Outline application with some matters reserved (access only) for the erection of 34 No. dwellings with access from Hoe Lane, Flansham. This application is a Departure from the Development Plan.

Bonhams Hoe Lane Flansham Bognor Regis

Thank you for your internet representation made on 18th July 2017 which has been recorded as **'an objection'** with the comments as follows:

Visibility Splay 2.4m x 43m

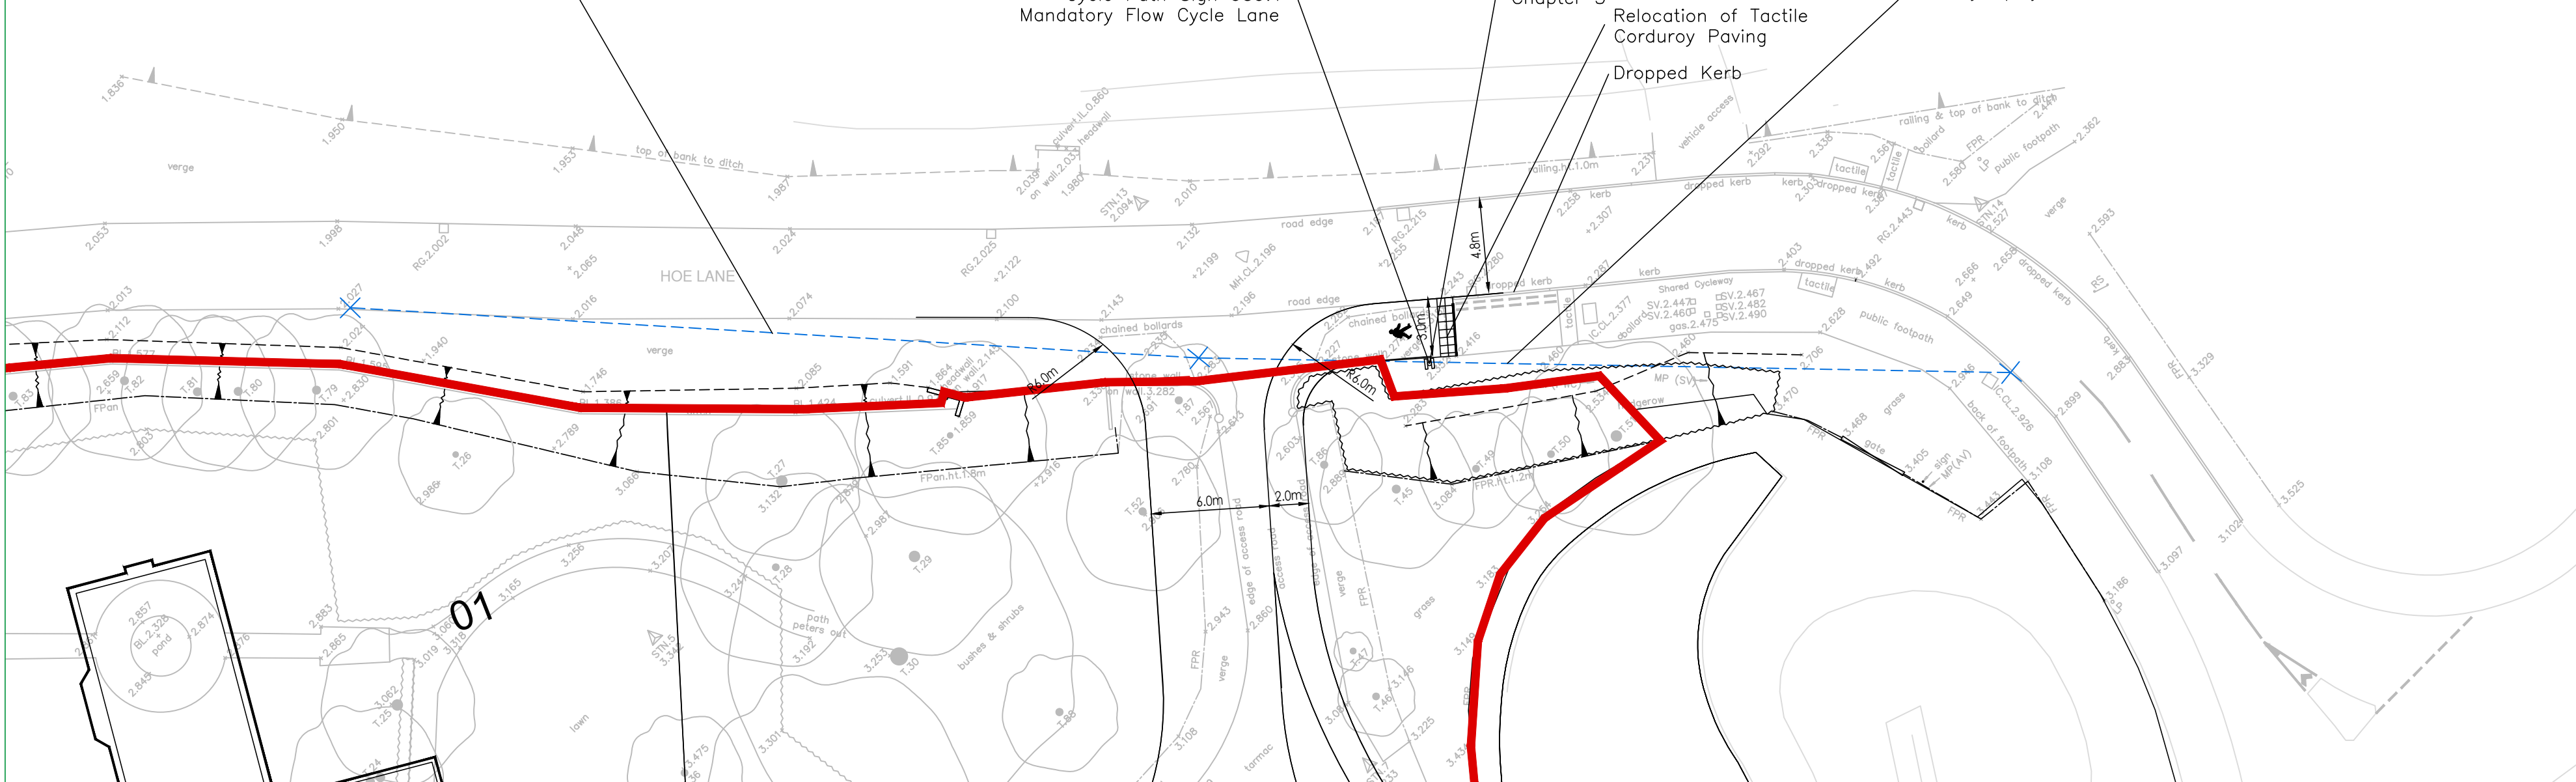
I have been studying the RGP transport statement in connection with this proposal and specifically the access visibility splay drawing. The dimensions they quote that are required for safe access and egress to the site are 2.4 X 43m. To be able to see 43 metres towards the roundabout it is obvious from their drawings that all the trees on the side of the road would have to go.

This would be a desecration of the character of the Lane and would compound the indiscreet nature of this new development, totally out of place in this historic village. I hope this point is taken into consideration.
